Figure 9.6 – Local Highway Network

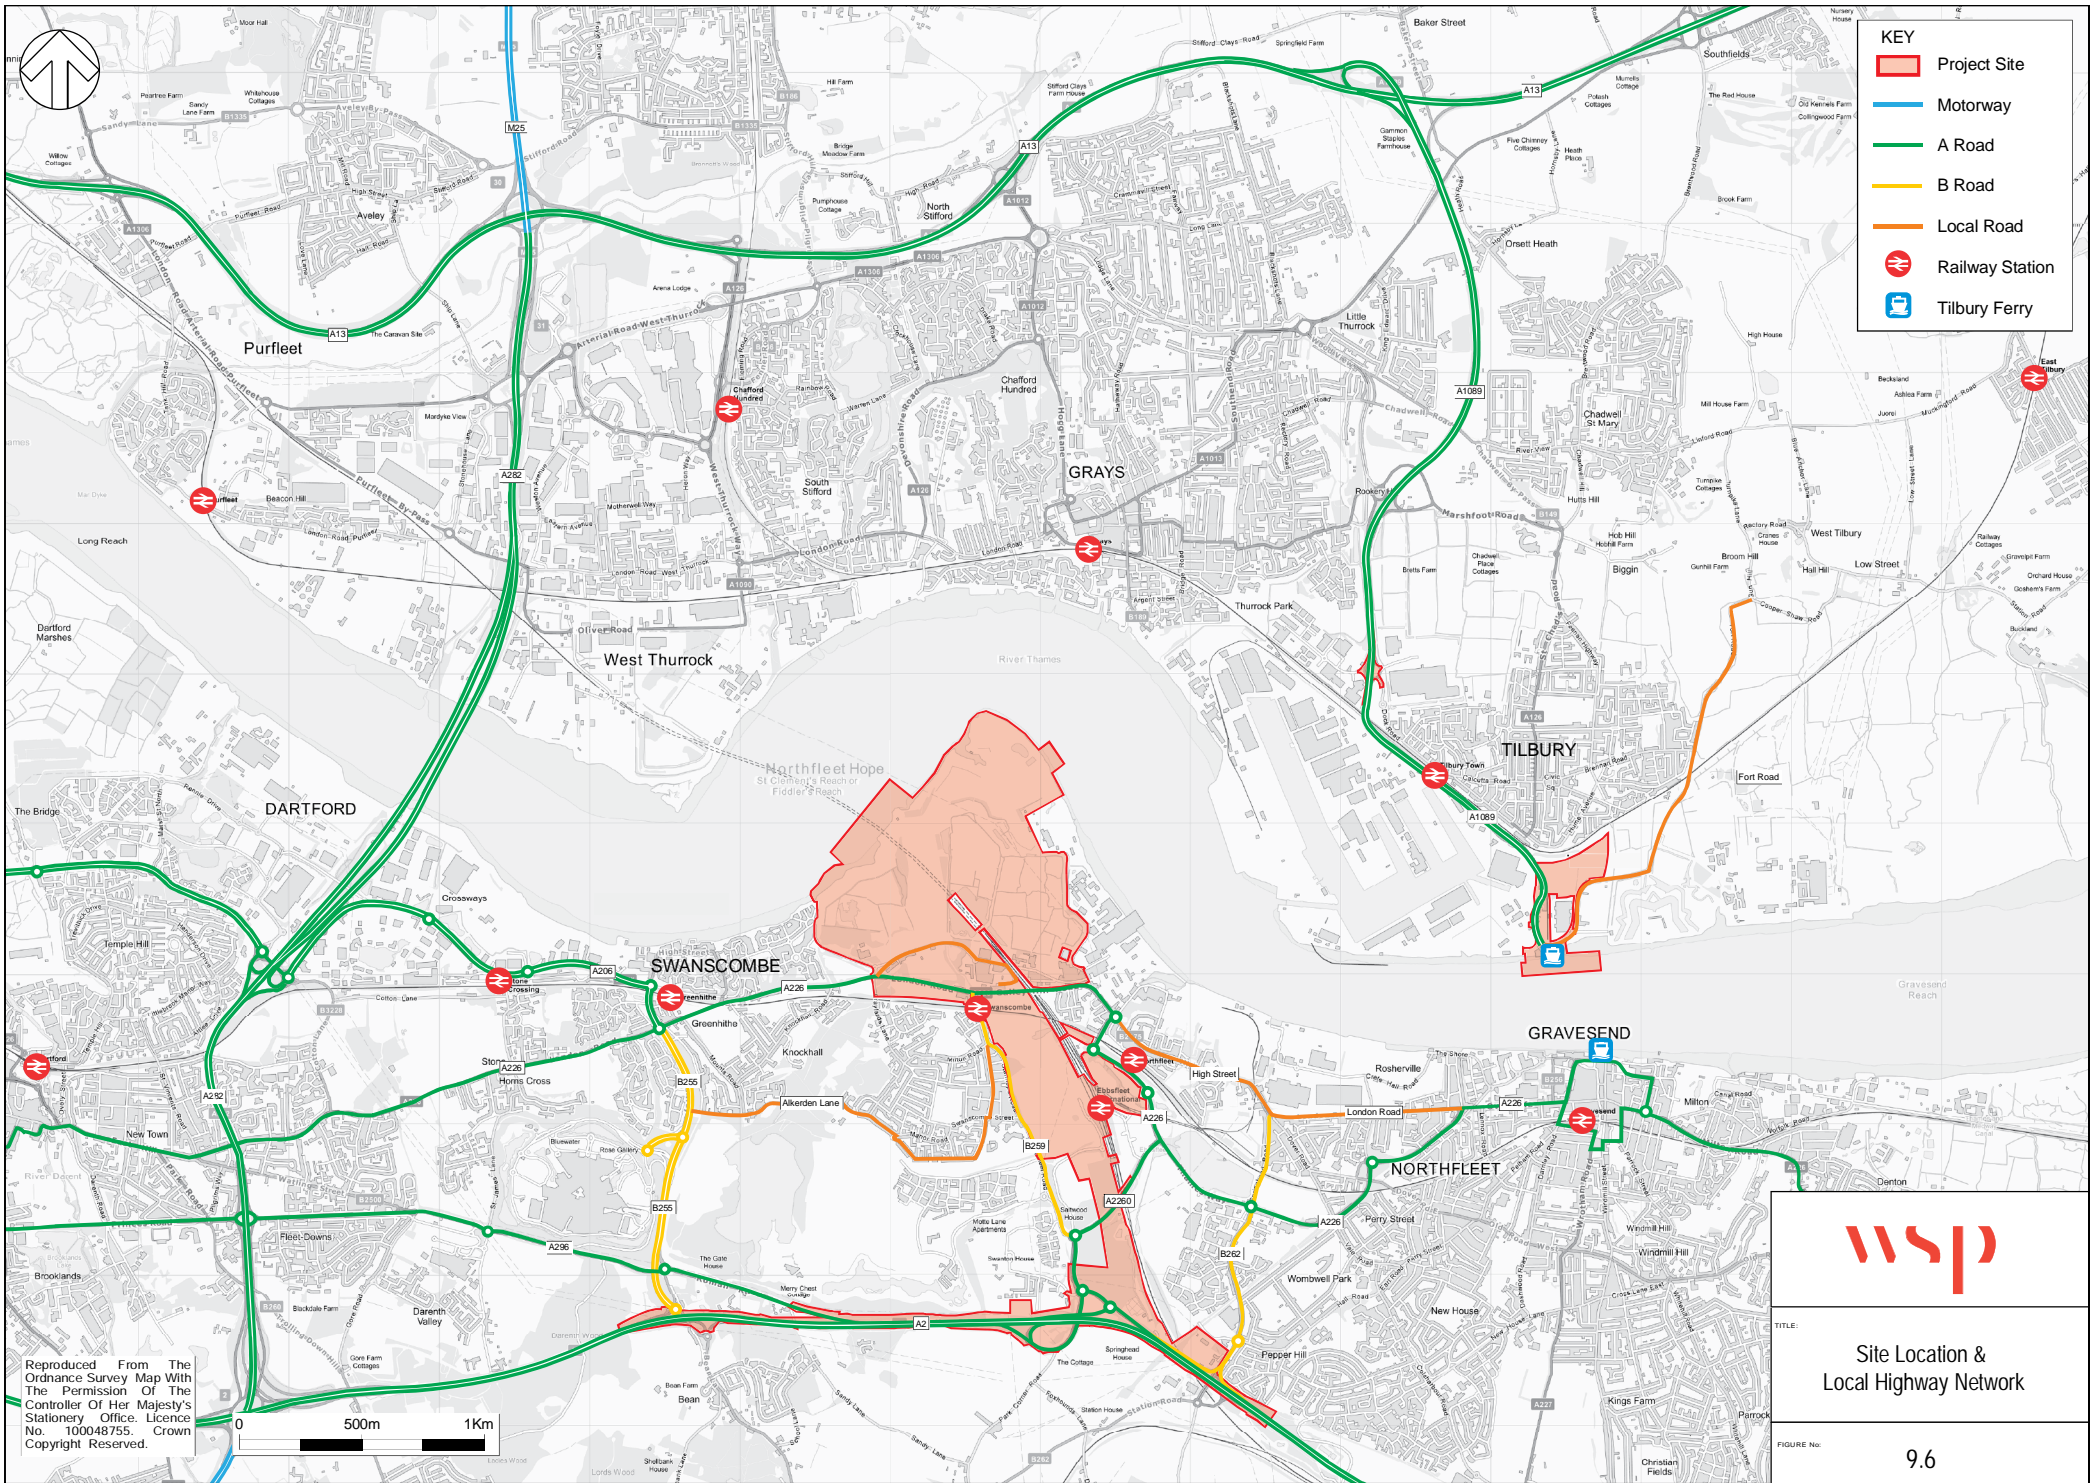
The figure above is supposed to show the local road network. However, in this figure LR are showing the A13 up to and past the A1089 as part of the Strategic Road Network, yet they omitted it in the Strategic Highway Network figure 9.6, plus the A13 is only Highways England's up to the A1089 it then becomes part of Thurrock Highways. LR are also still showing the actual A1089 as a local highway, as opposed to strategic highway, when in fact it is part of the Strategic Road Network.

This just adds to the confusion for those not familiar with the highways network, and clearly shows that LR have no idea, and there isn't even any continuity in their errors across the two figures. How are we meant to have any confidence in their planning when errors like these are so obviously being made?
